Recommendation: Approve

Applicant: Dave & Amy Brace

Proposal: Discharge of Conditions 3 (doors, windows and louvres), 4 (stone sample panel) and 5 (roof material sample) of 20/00672/F

D
01

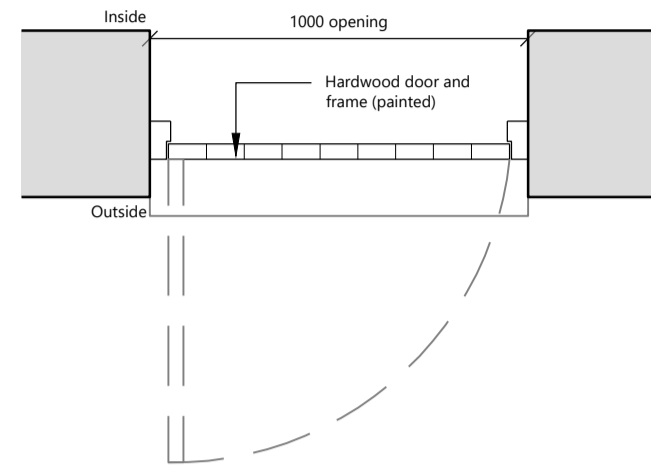
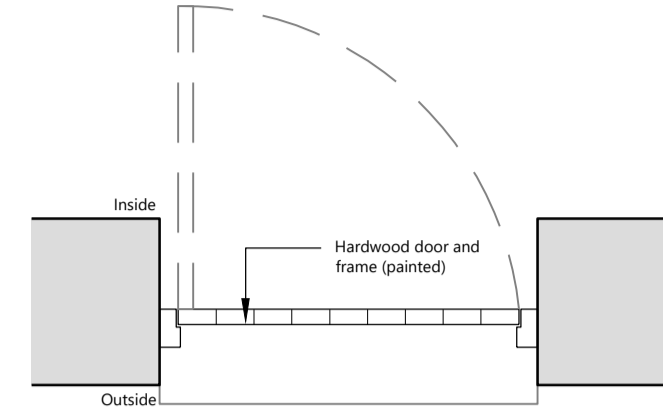
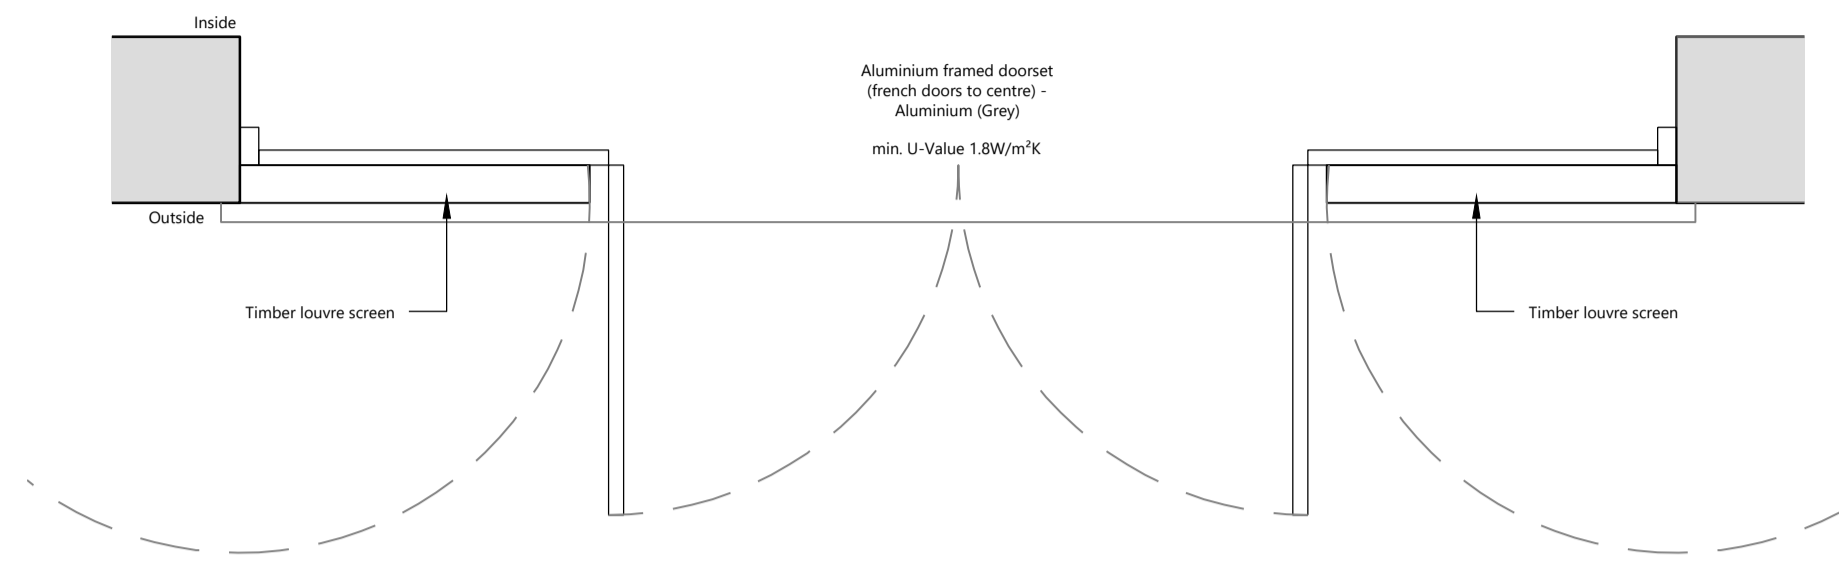
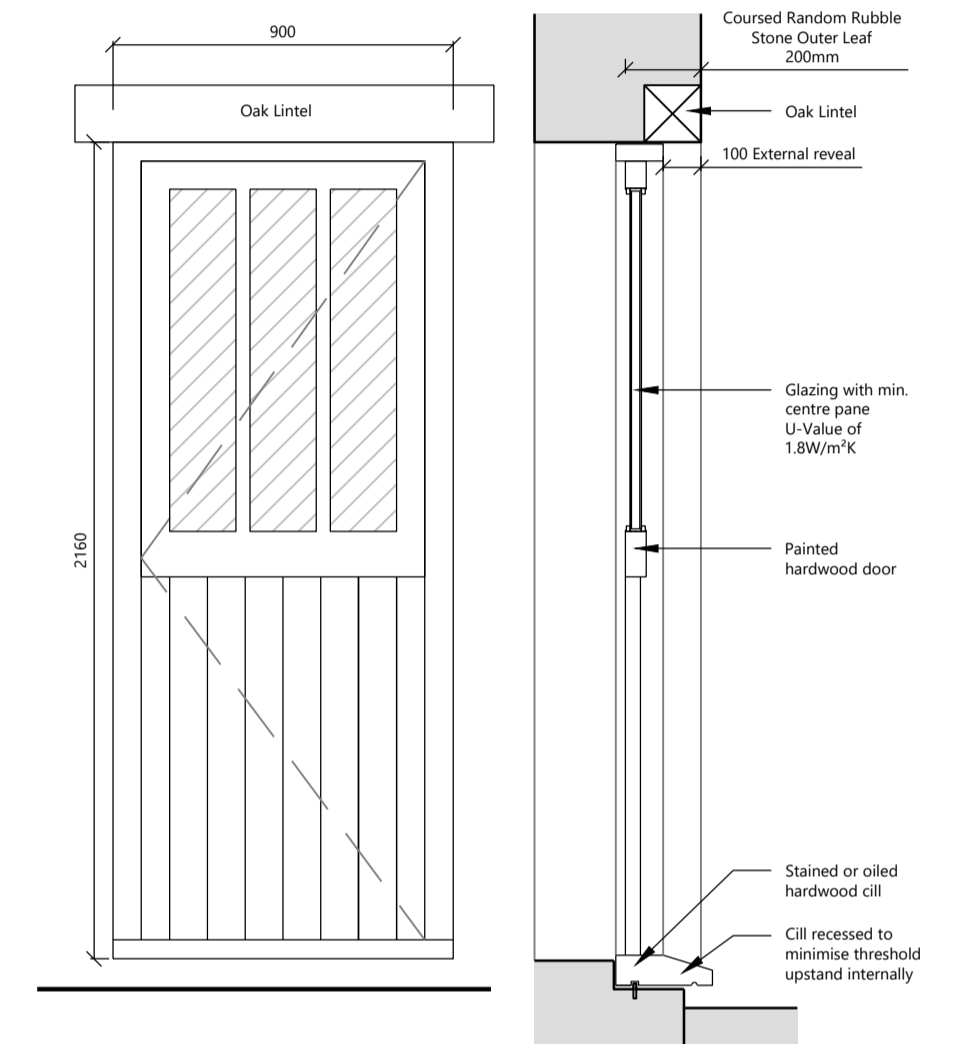
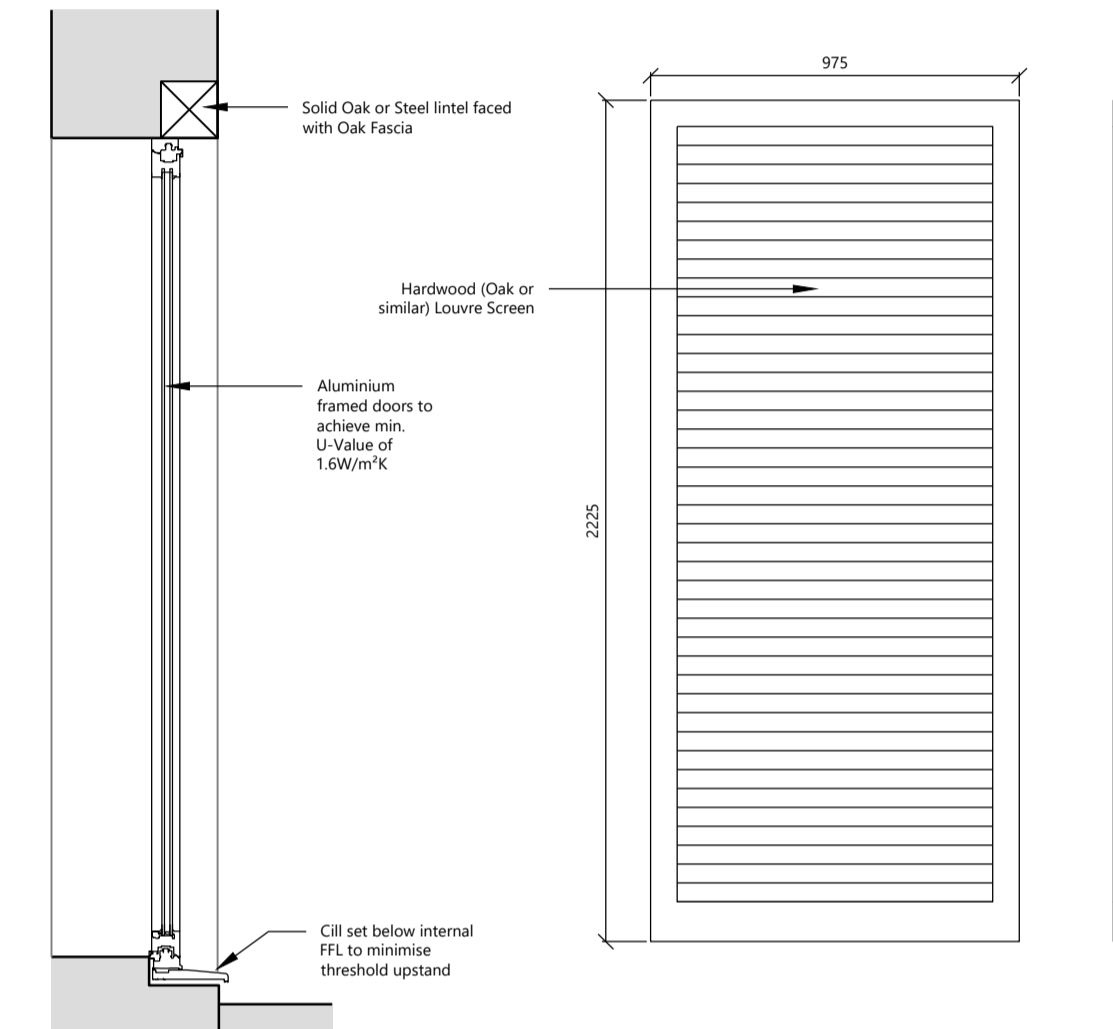
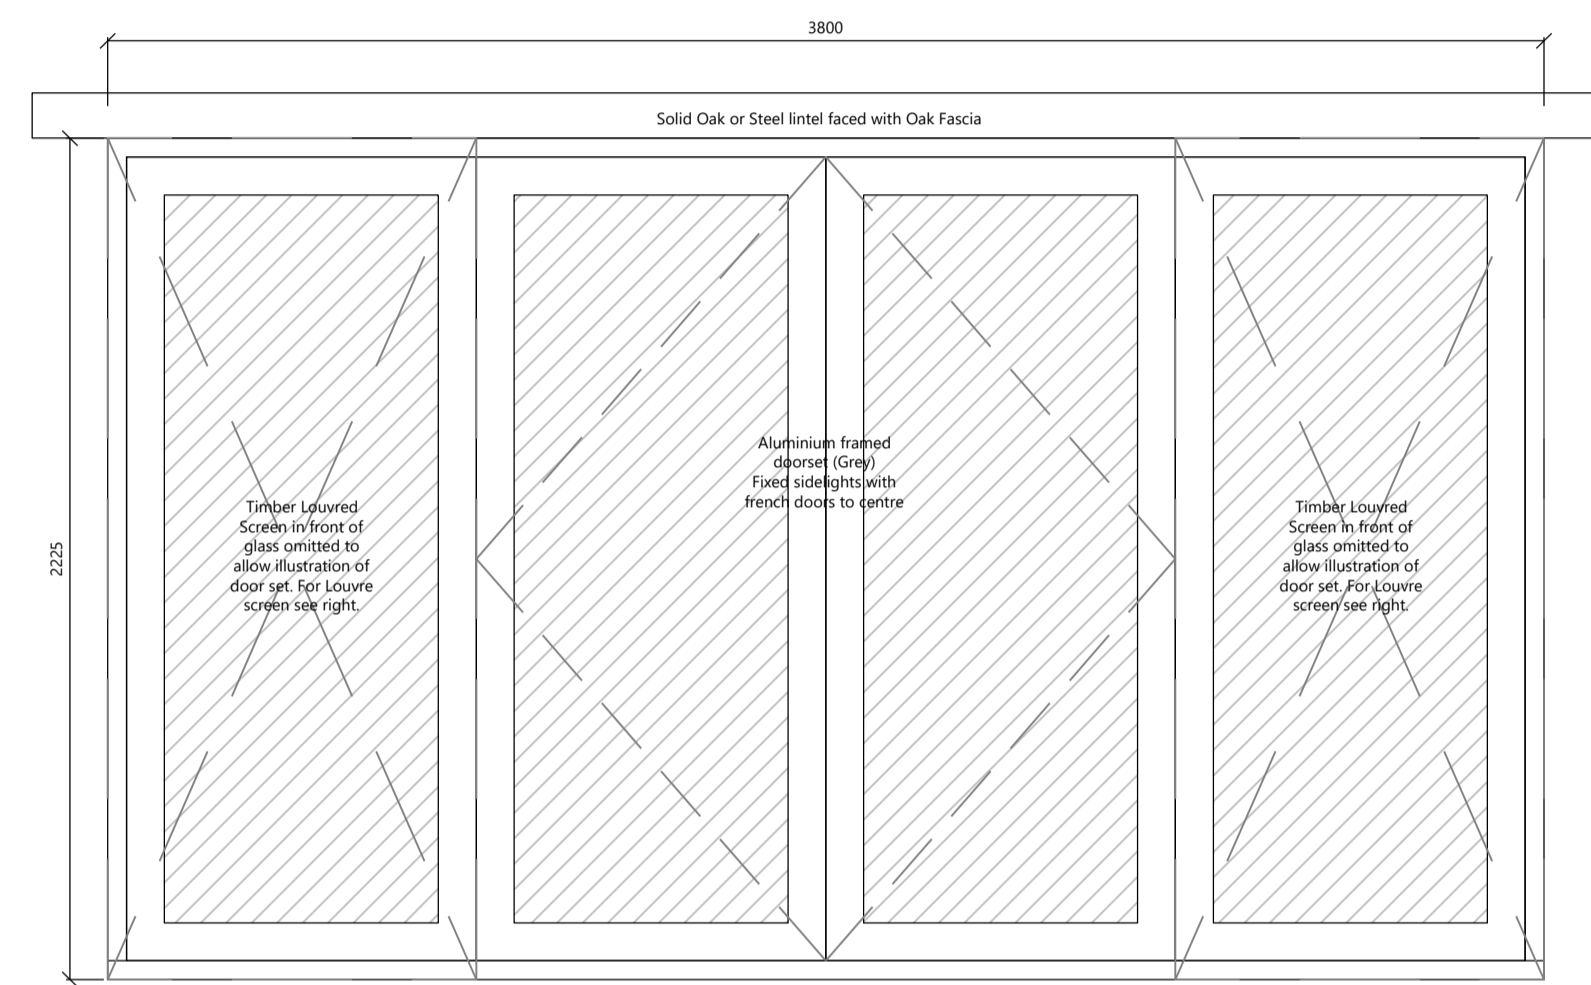
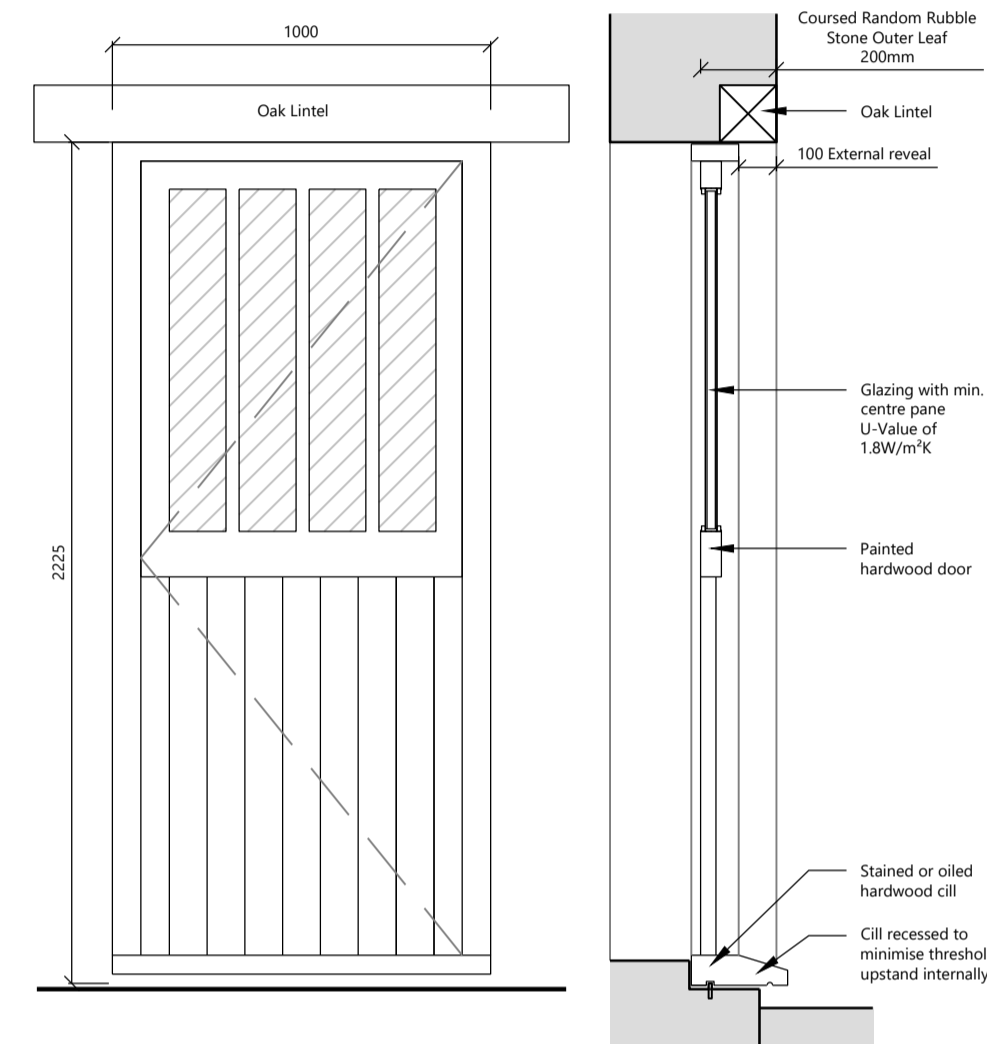
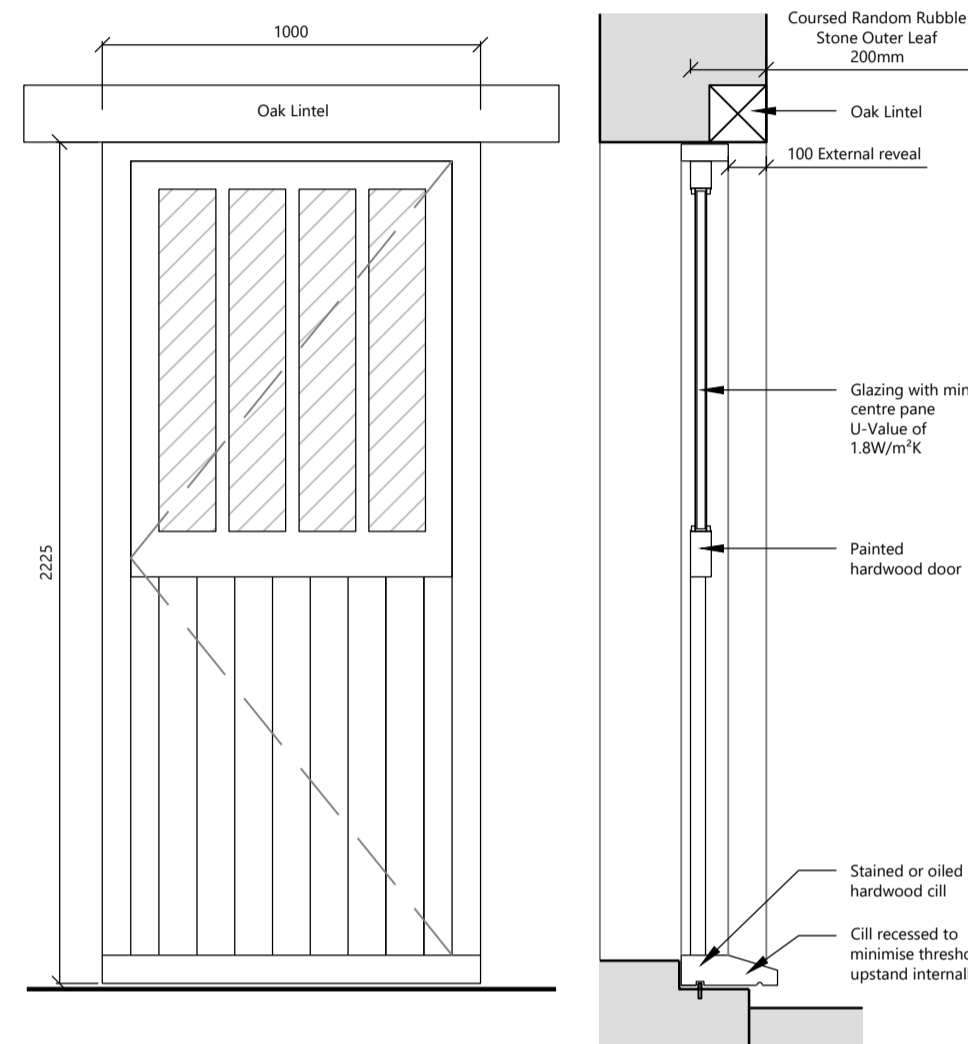
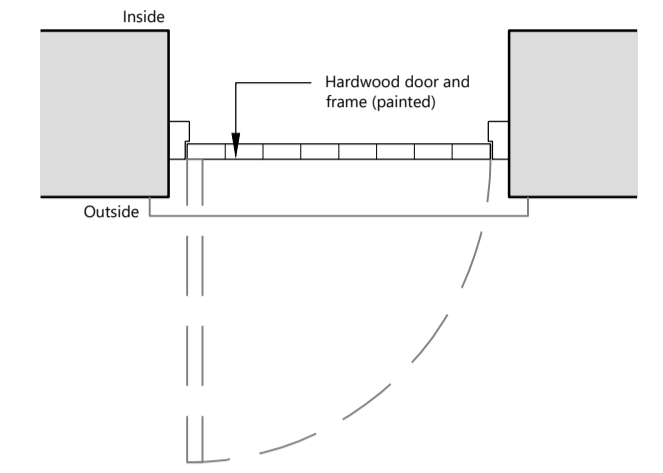
Raised various questions regarding the windows. There are not enough details to discharge the joinery details condition, and the details of the door proposed are not correct – Objection

The agent has confirmed that the mid rail of the door would be flush as requested by the Conservation Officer.

The joinery details are now considered acceptable.
